Thank you for the opportunity to comment on the short plat of approximately 4.89 acres into 3 lots, proposed by Michael and Dottie Rogers [SP-08-00023]. We have reviewed the application and have the following comments.

TO: Trudie Pettit, Community Development Services  
FROM: Christina Wollman, Planner II *CW*  
DATE: July 30, 2008  
SUBJECT: Mr. Rogers Short Plat SP-80-23

## MR. ROGERS ROAD VARIANCE 08-22

**MR. ROGERS SHORT PLAT**  
**PART OF SECTION 31, T. 18 N., R. 19 E., W.M.**  
**KITTITAS COUNTY, WASHINGTON**

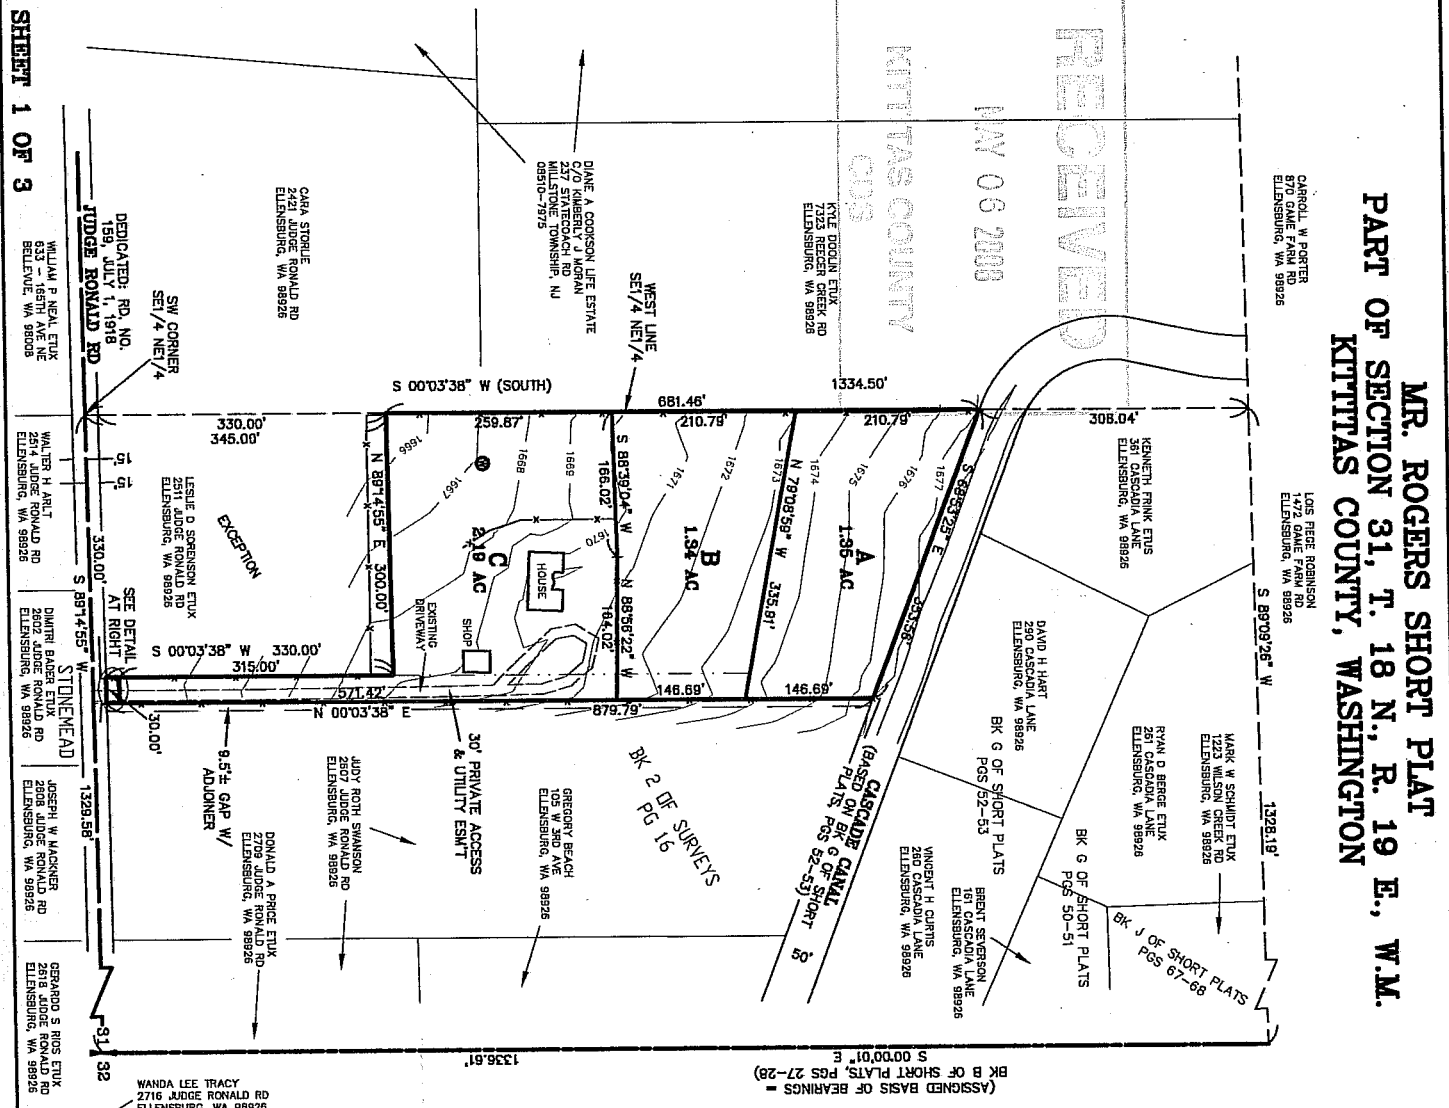
2. Easement Width: Road Variance 08-22 was approved allowing the applicant to construct the road within a 30' easement instead of the required 40' easement.

3. Private Road Improvements: Access from Judge Ronald Road to the cul-de-sac shall be constructed to meet or exceed the requirements of a High-Density Private Road that serves 3-14 tax parcels. The applicant has received a variance for easement width. See Kittitas County Road Standards, 9/6/05 edition.

4. Cul-de-Sac: A cul-de-sac turn-around having an outside right-of-way easement diameter of at least 110 feet shall be constructed at the closed end of all dead-end roads serving 3 or more lots. The driving surface shall be at least 96 feet in diameter. Cul-de-sacs must also conform to the requirements specified by the 2006 International Fire Code. Contact the Fire Marshal regarding any additional cul-de-sac requirements.

Road may be constructed within the 30' easement and shall meet all other requirements of Kittitas County Road Standards.
